**Your Ref: 2024/93594**  
**Our Ref: A007078**

**12th March 2025**

**Hollinghurst Farm, 76 Hall Ing Lane, Honley, Holmfirth – Erection of 9 dwellings including associated works**

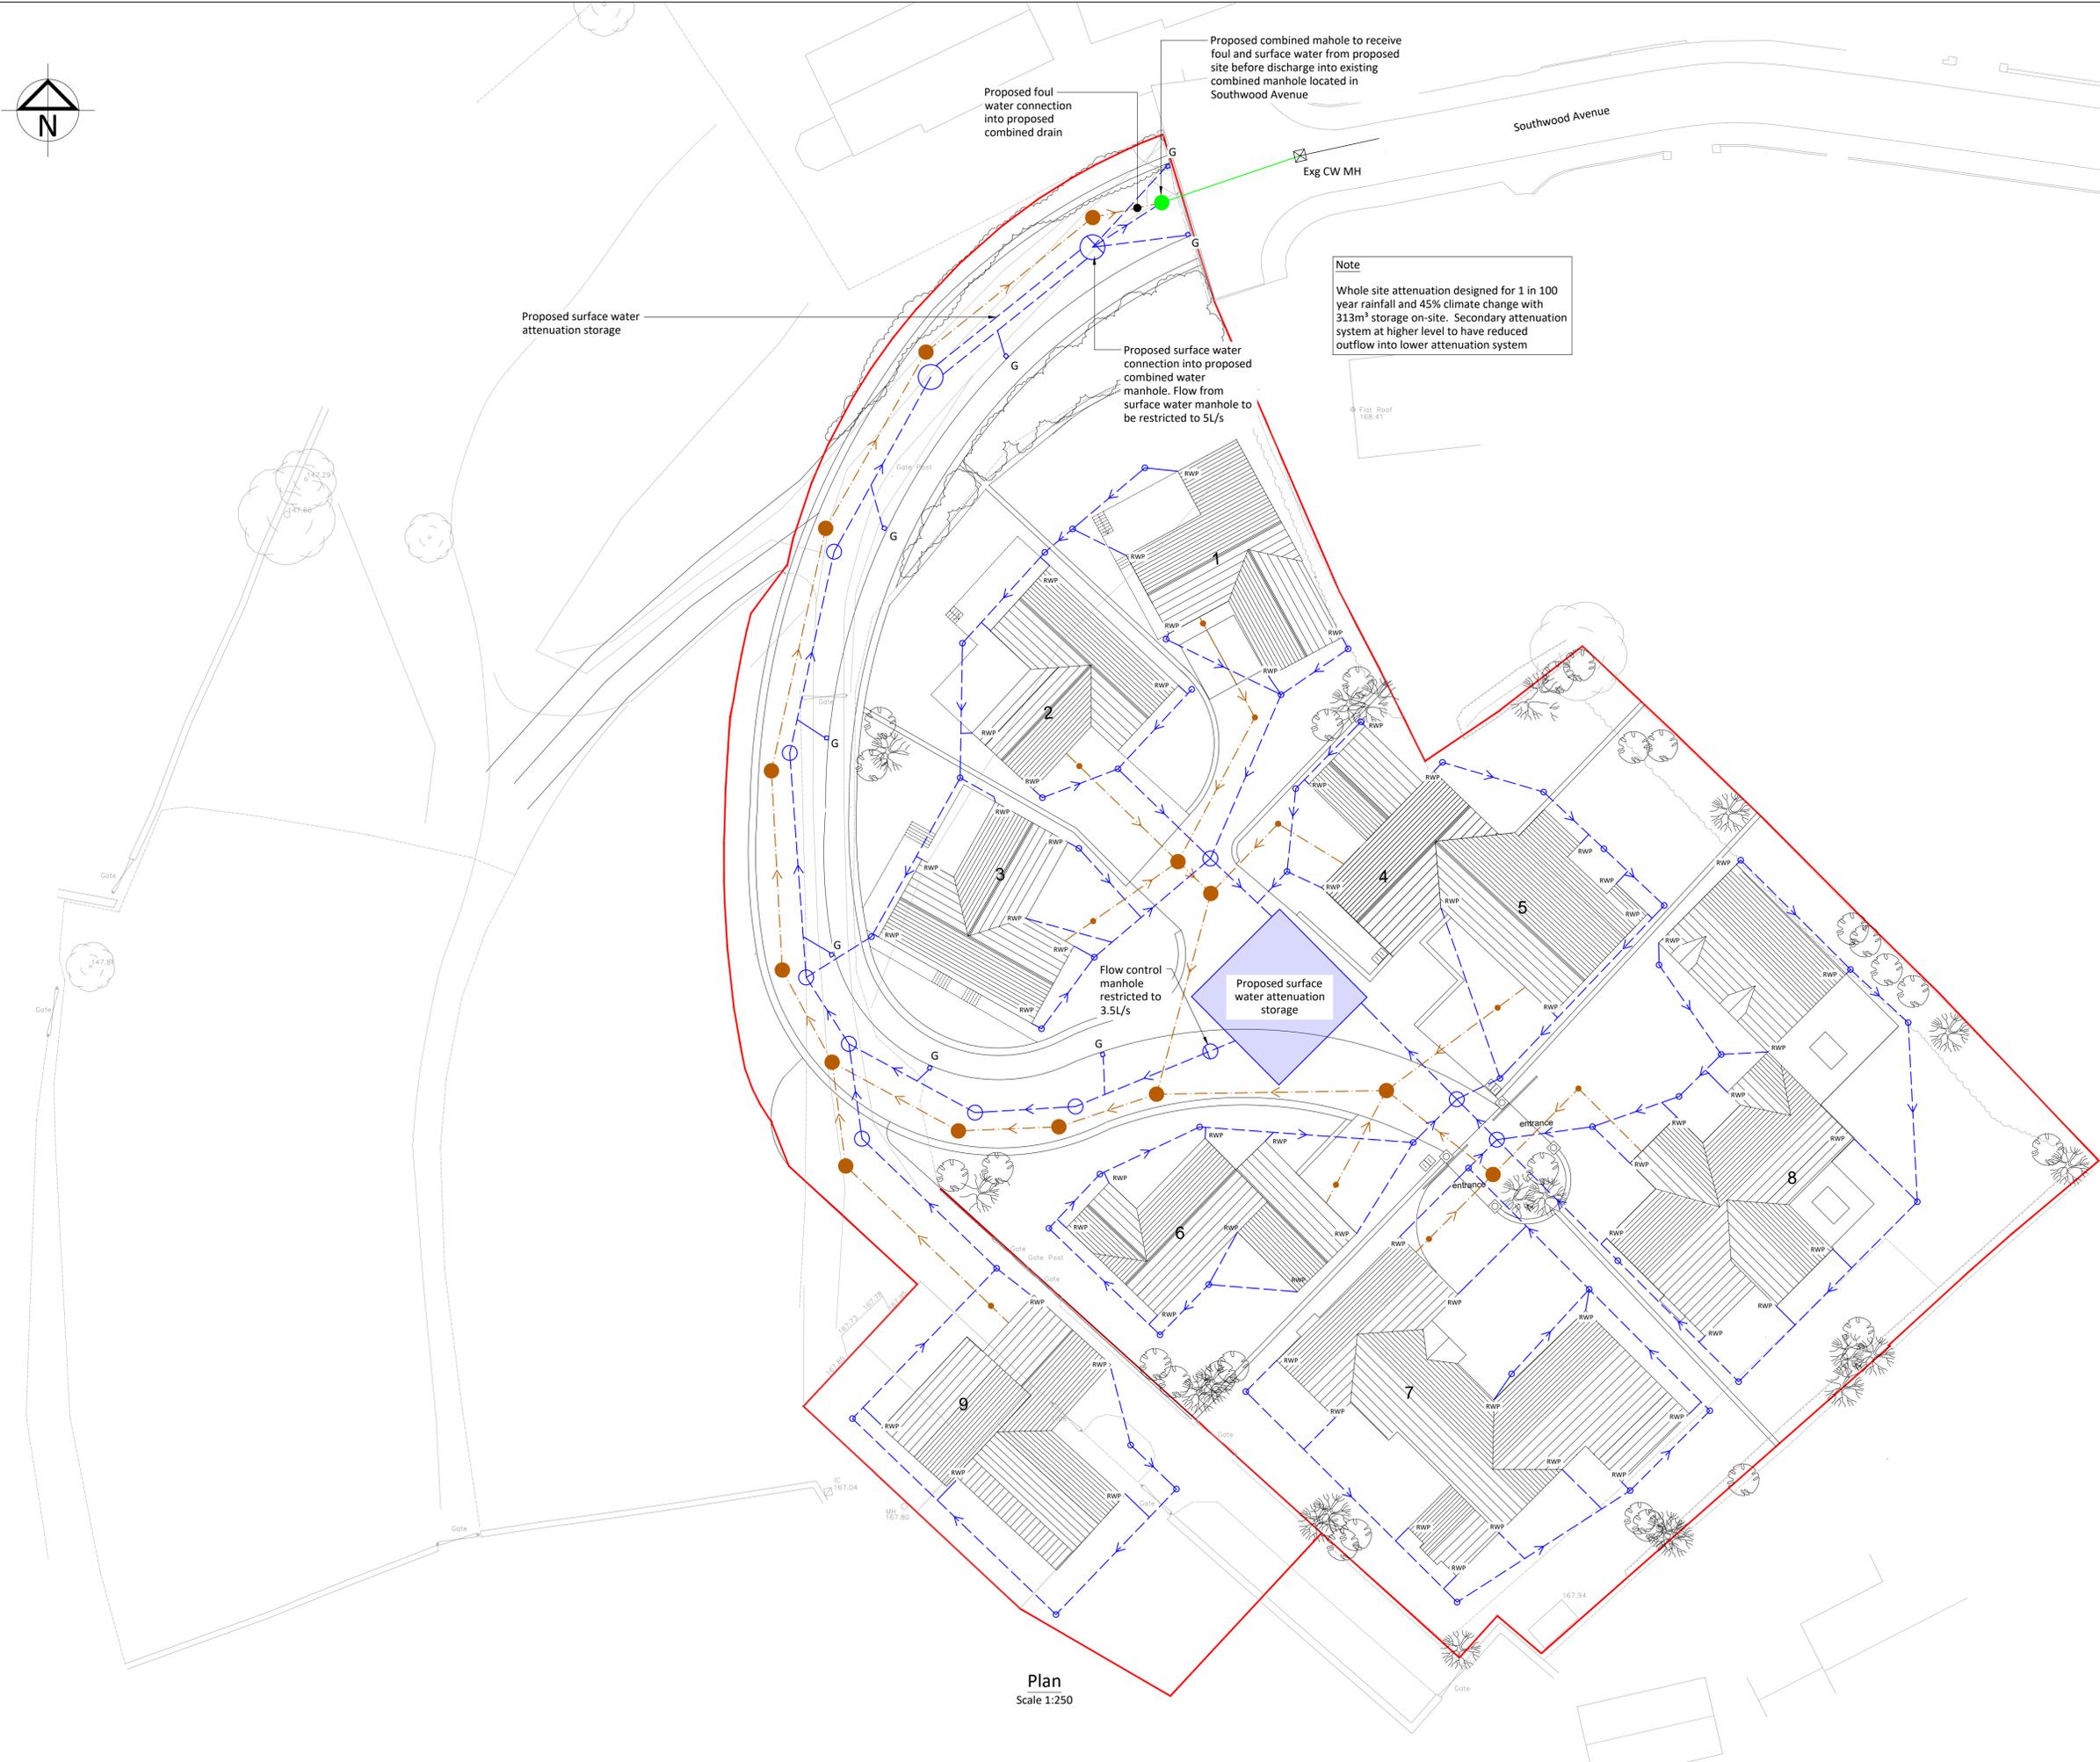
1.) The submitted 'Flood Risk Assessment with Outline Drainage Strategy' prepared by 186-62-DOC001, dated 19/12/2024 requires amendments, but if planning permission is granted, the matter can be dealt with via condition.

- a.) Foul water will discharge to public foul.
- b.) Sub-soil conditions do not support the use of soakaways due to site topography.
- c.) Surface water will discharge to public combined water sewer via storage with restricted discharge of 5litres/second - this rate is not acceptable.
- d.) The means of surface water management has not been properly considered within the FRA/drainage report. Yorkshire Water requires further information regarding the means of draining surface water from the development

3.) The developer is proposing to discharge surface water to public sewer however, sustainable development requires appropriate surface water disposal, particularly as the combined water sewer does not have the capacity to accept surface water.

- i) evidence that other means of surface water drainage have been properly considered and why they have been discounted; and**
- ii) the means of discharging to the public sewer network at a rate not to exceed 3.5 litres per second.**

- a.) Yorkshire Water promote the surface water disposal hierarchy and the developer must provide evidence to demonstrate that surface water disposal via watercourse are not reasonably practical before considering disposal to public sewer.
- b.) The developer and LPA are strongly advised to seek comments on surface water disposal from other drainage bodies as further restrictions may be imposed.
- c.) Ludhill Dike is approximately 117 metres from the site, which may prove an acceptable means of surface water disposal - appropriate 3rd part land permission must be sought.
- d.) As a last resort, and upon receipt of satisfactory evidence to confirm the reasons for rejection of other methods of surface water disposal, curtilage surface water may discharge to public combined water sewer at a restricted rate not to exceed 3.5 litres per second.
